Department for Transport

Application by Associated British Ports (“the Applicant”) Seeking Development Consent for the Proposed Immingham Eastern Ro-Ro Terminal Project (“the Proposed Development”)

Impact Protection Measures

Drawing number
B2429400-JAC-00-ZZ-DR-ZZ-0202

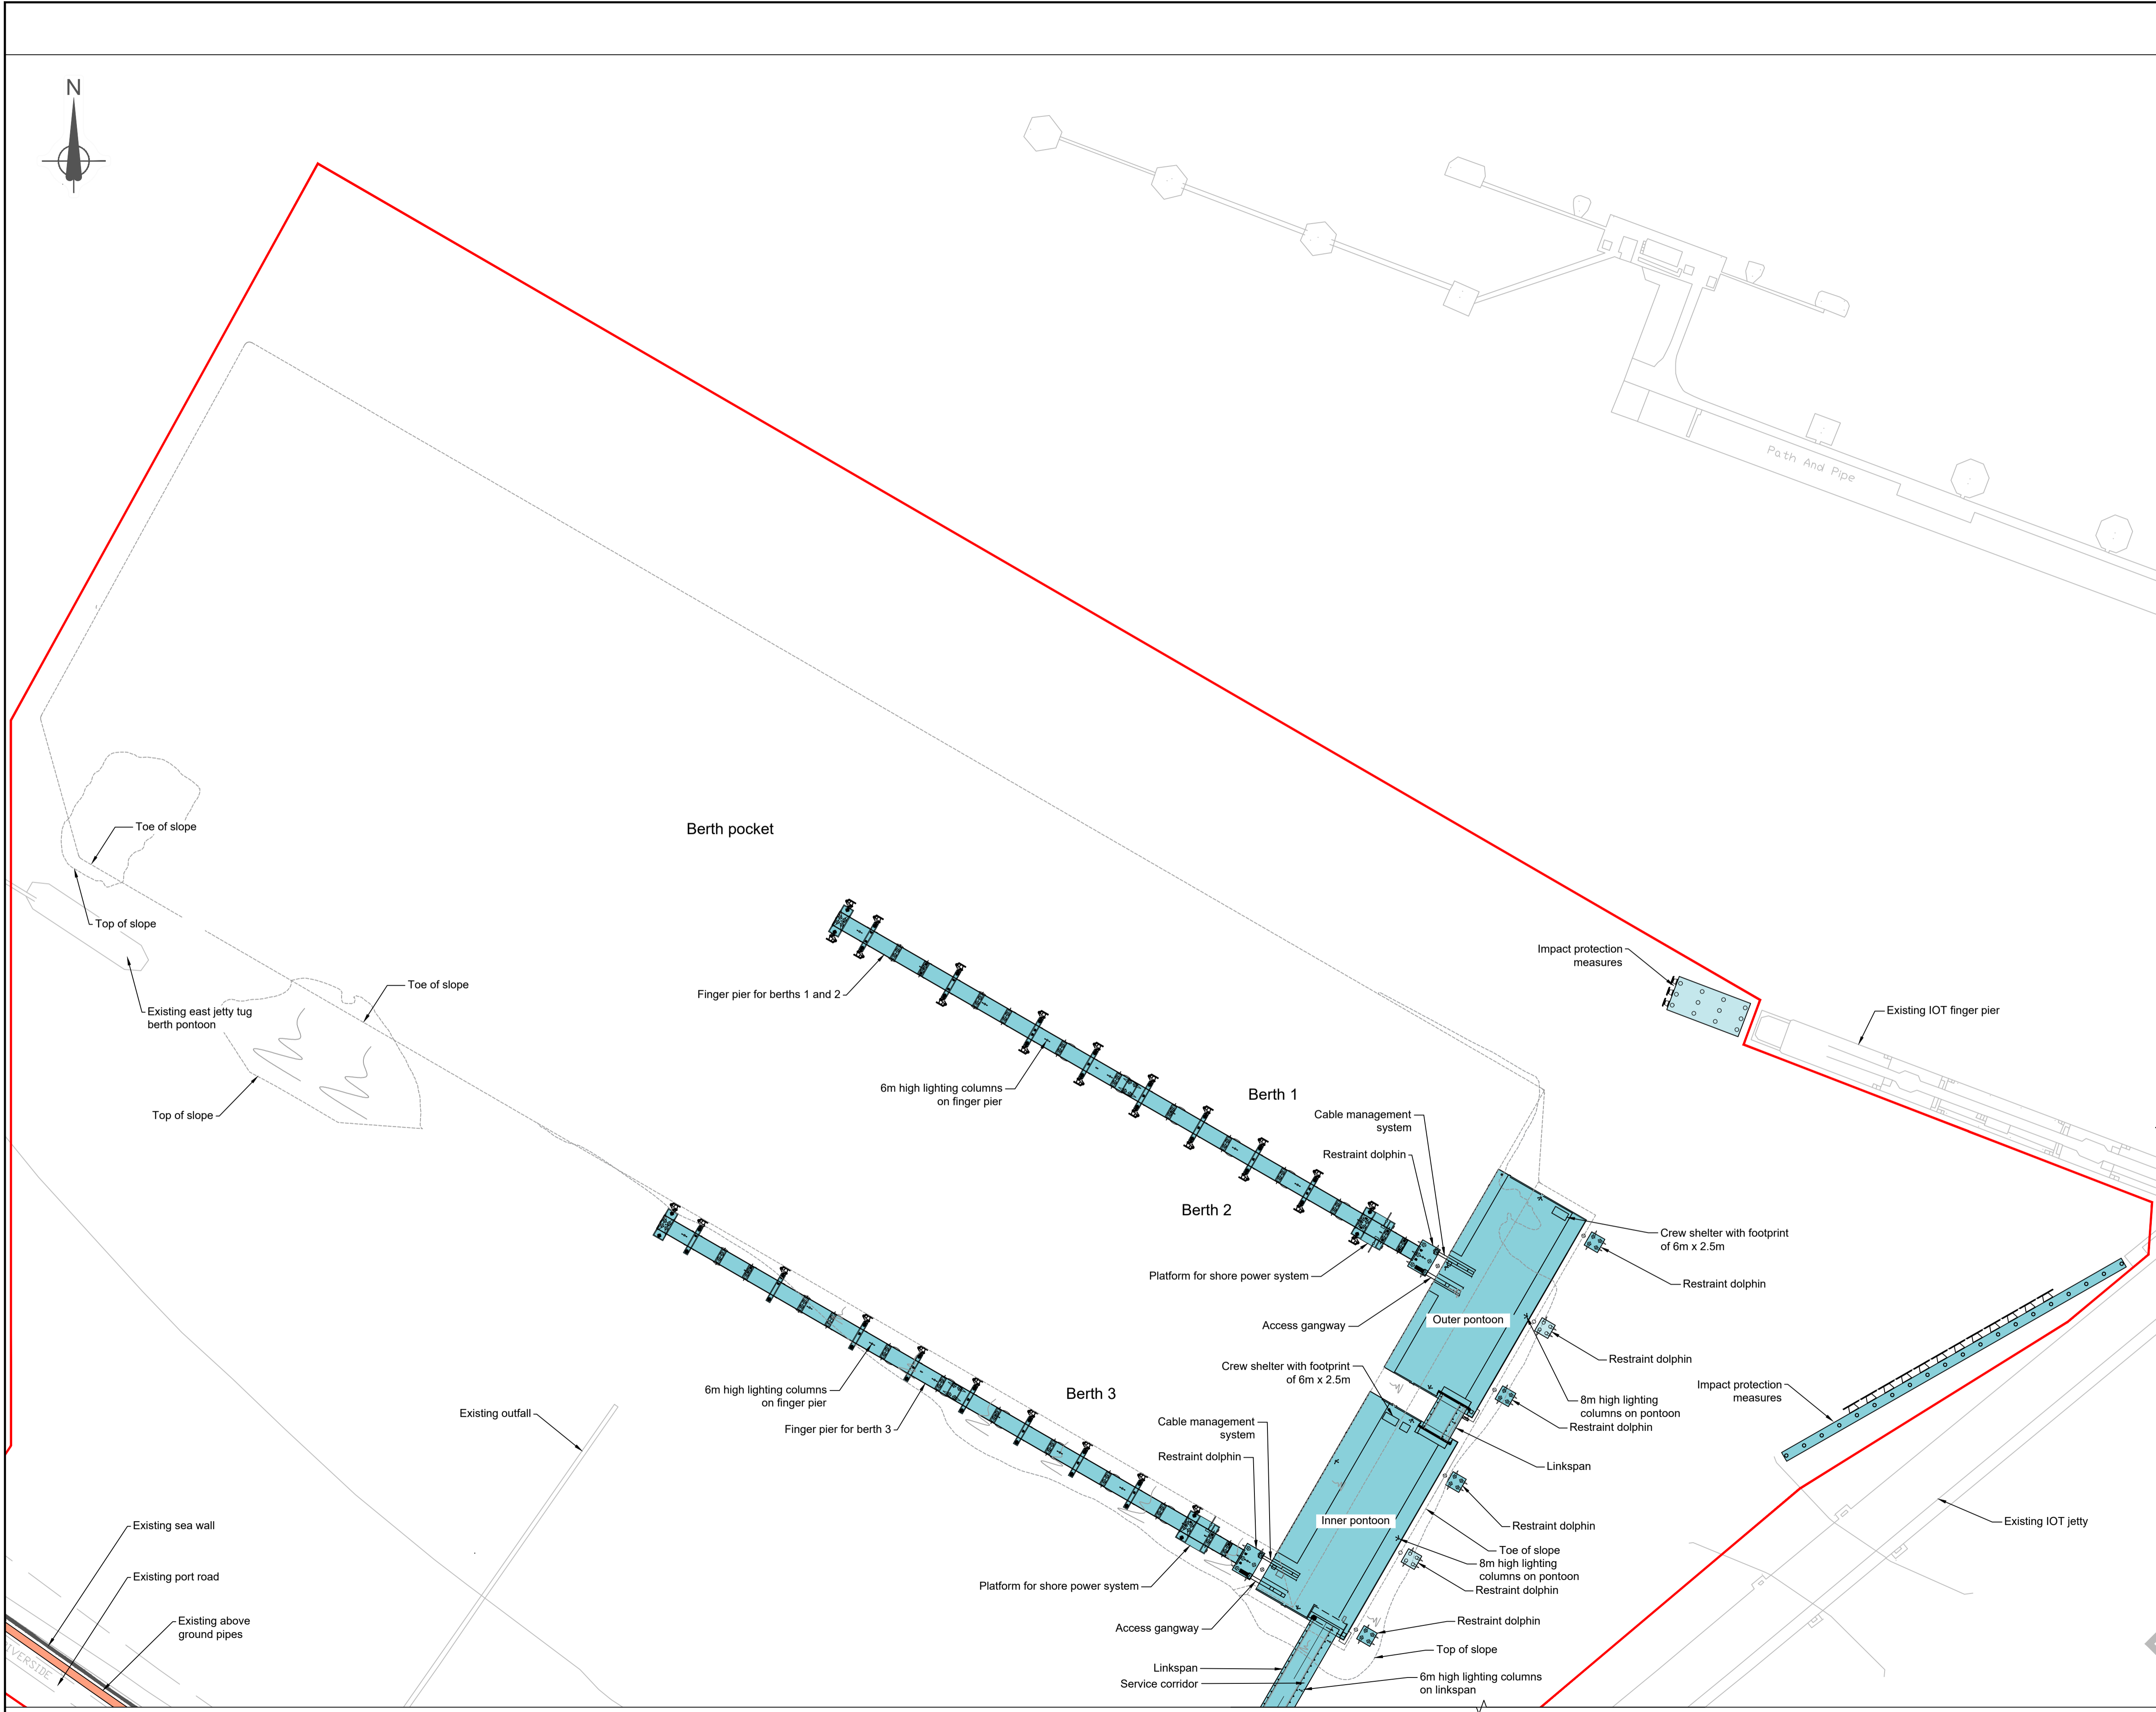
7. The Secretary of State is aware that during the examination, IOT Operators and other Interested Parties submitted representations on the need for Impact Protection Measures to

reduce the risk of vessel allision with the IOT Operators' infrastructure to as low as reasonably possible.

8. The Secretary of State considers that if he were to agree with the IOT Operators' position on this matter the wording of Requirement 18 in the Applicant's final version of the Order might require amendment so that Work No. 3(b), the 'dolphin' IPM at the western end of the IOT's finger pier, would be constructed prior to the first use of Berth 1. Requirement 19 might also need amendment to aid precision and enforceability, and to reflect the changes to Requirement 18. The suggested amendments to both Requirements are shown in red text in the document attached to this letter. The Secretary of State invites comments from the **Applicant, IOT Operators and any other Interested Party** on those amendments.

Impact Protection Measures for the IOT finger pier

19. – Prior to the commencement of ~~construction of the authorised development] or [Prior to the commencement of~~ commercial ~~operations at operation of berth 1, using the authorised development]~~ berth numbering adopted on General Arrangements Plan B2429400-JAC-00-ZZ DR-ZZ-0202 Revision P04, the undertaker must:

- a. notify the Statutory Conservancy and Navigation Authority, the dock master, the MMO and the ~~operator of the Humber Oil 8 Terminal~~ IOT Operators of its intention to install the impact protection measures; comprising Work No. 3(b);
- b. agree a programme of works with the parties identified in sub-paragraph (~~1a~~) above; and
- c. install the impact protection measures detailed as Work No. 3"(b).
